27 November 2012

SF2012/000805
CF2012/011225
MJ

NELSON BAY ROAD (MR108): EXHIBITION OF ENVIRONMENTAL ASSESSMENT - SECTION 75W MODIFICATION OF ACCESS TO MACCAS SAND PROJECT, LOT 218 DP1044608 (08_0142 MOD 1)

PLAN: PROPOSED ACCESS TRACK FROM
NELSON BAY RD TO LOT 218 DP 1044608

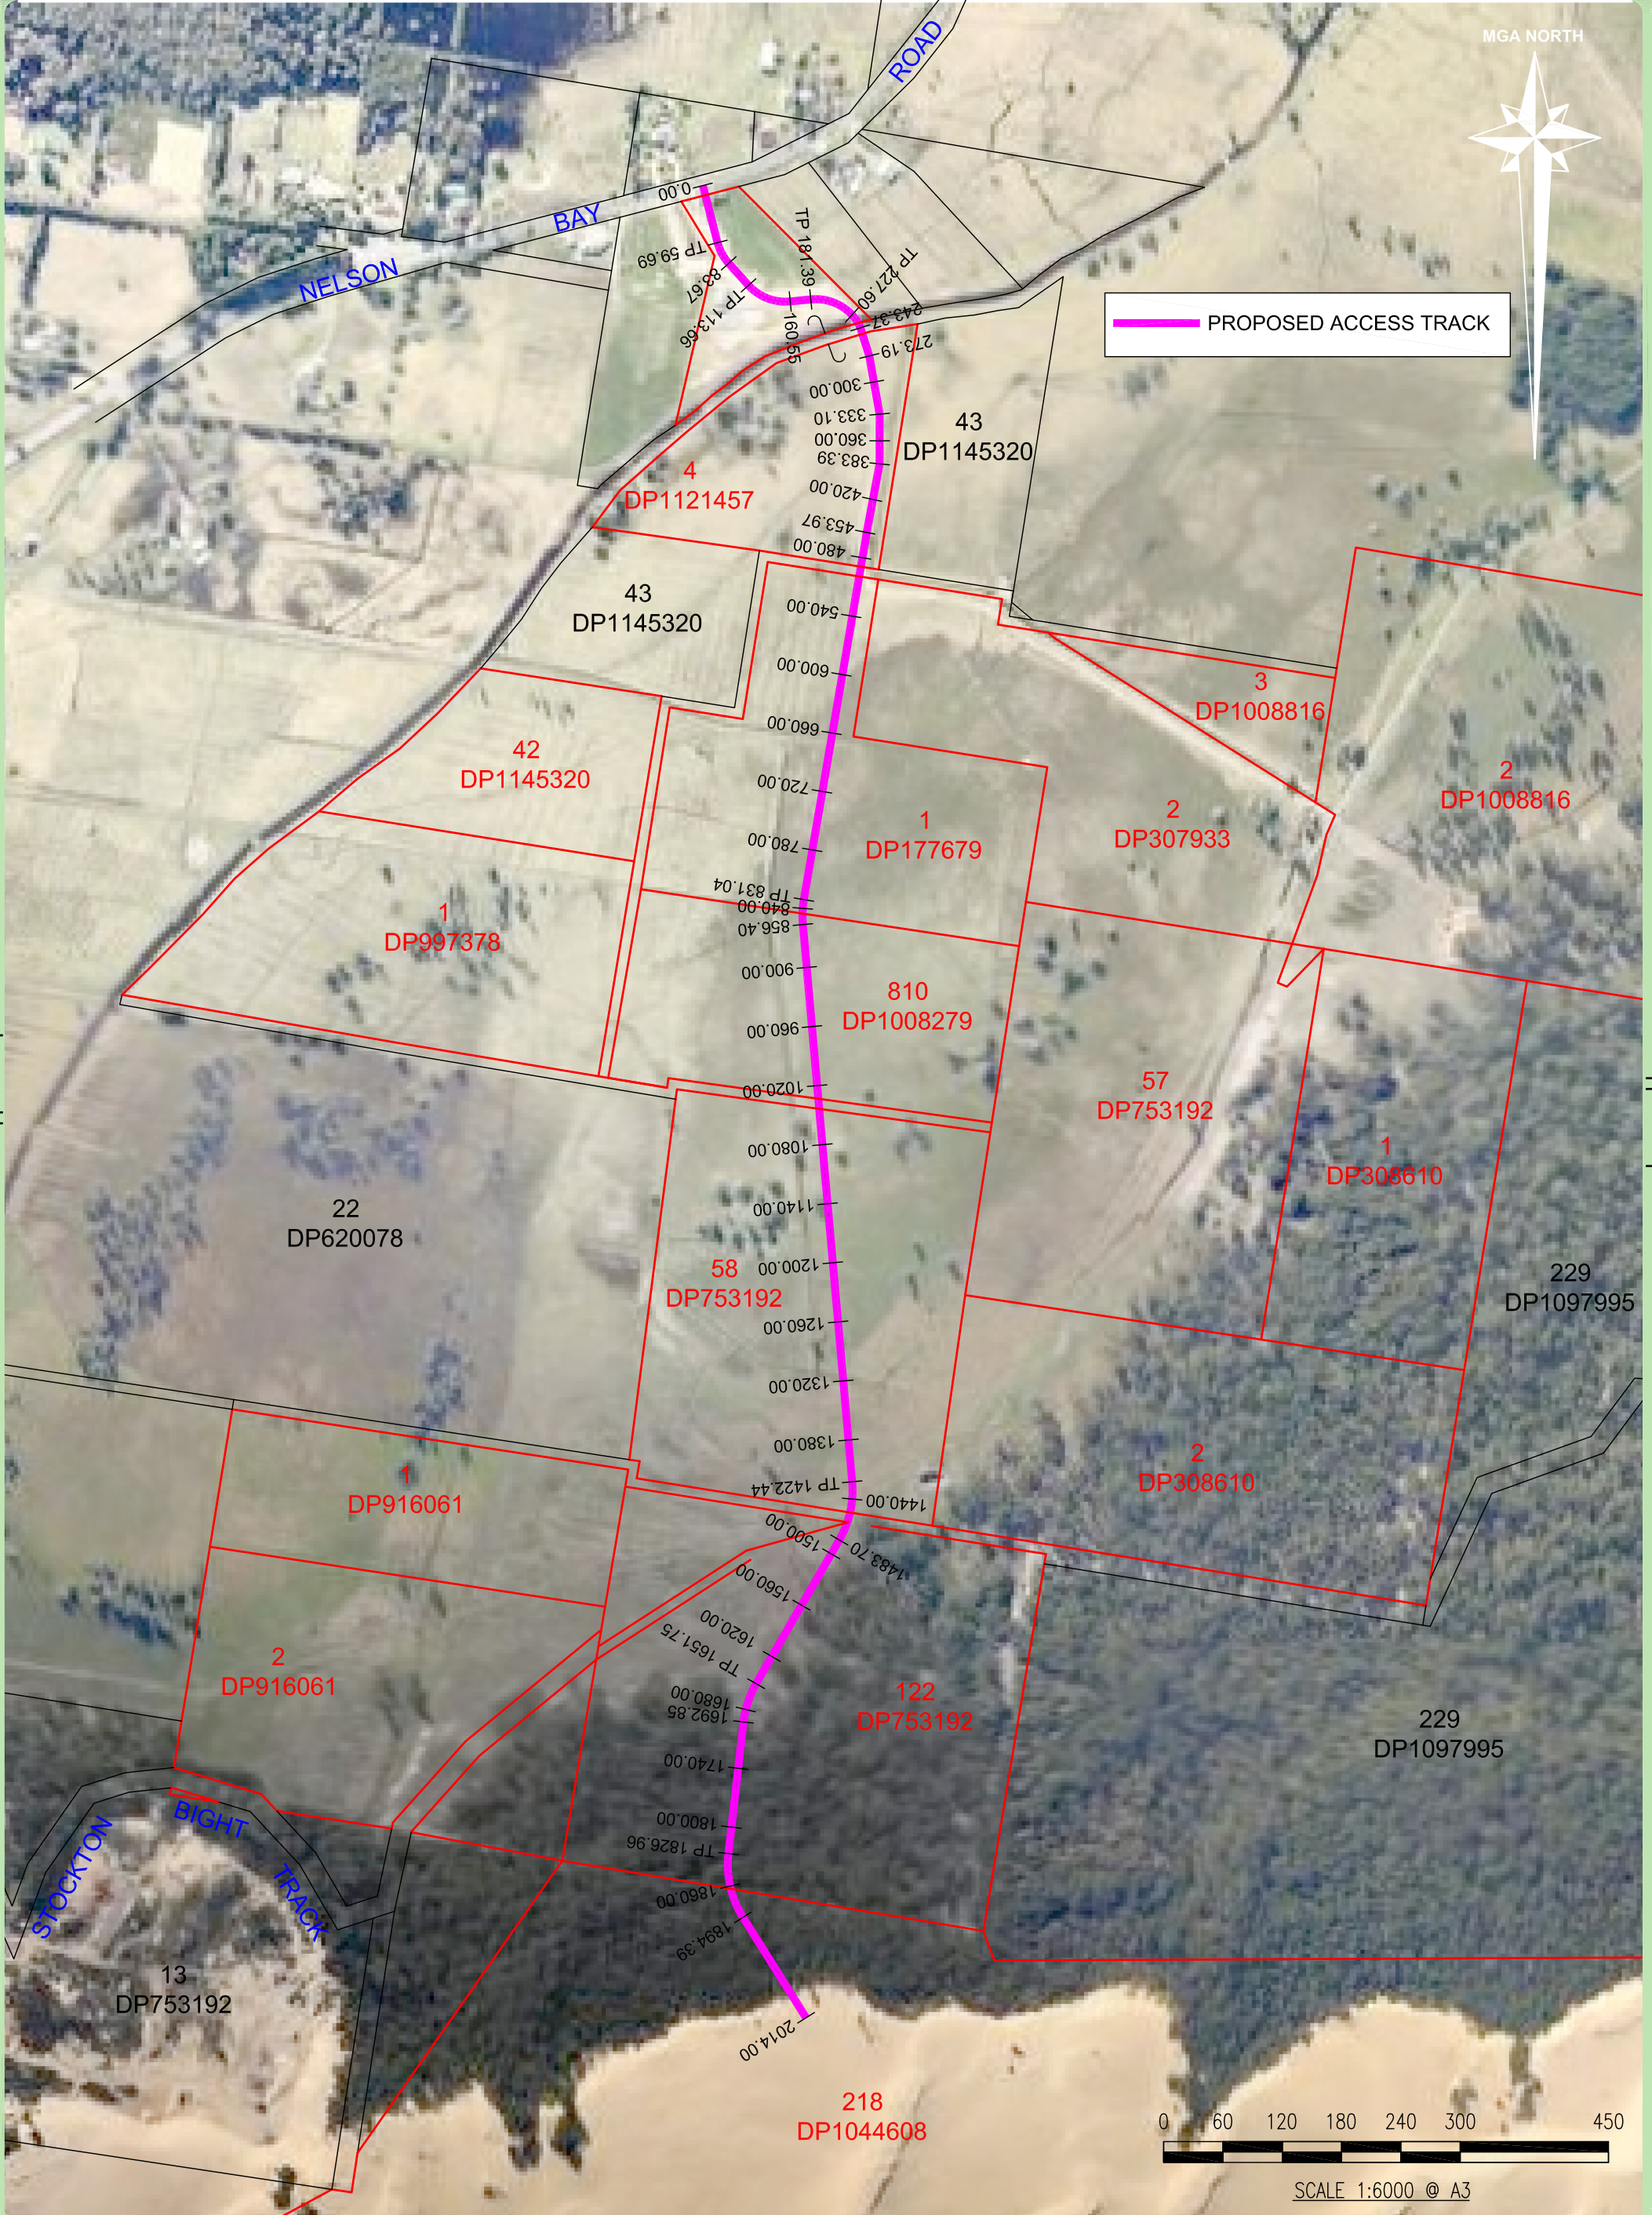
- The proposed intersection / access driveway on Nelson Bay Road shall be designed and constructed to accommodate left in / left out movements only and the design vehicle. A left turn deceleration lane and a left turn acceleration lane shall be provided at the intersection. The intersection shall be designed in accordance with the Austroads *Guide to Road Design 2009* (with RMS supplements) and relevant Australian Standards, to the satisfaction of RMS / Council. The intersection shall include the provision of a raised concrete median to physically prevent right turns into and out of the access road. Appropriate signage should also be provided to reinforce these restrictions.

- The intersection / access driveway shall be sealed to the returns, as a minimum, and designed / constructed in accordance with Council requirements.
- Street lighting shall be provided at the intersection of the access road and Nelson Bay Road to the relevant Australian Standard, or as determined by RMS.
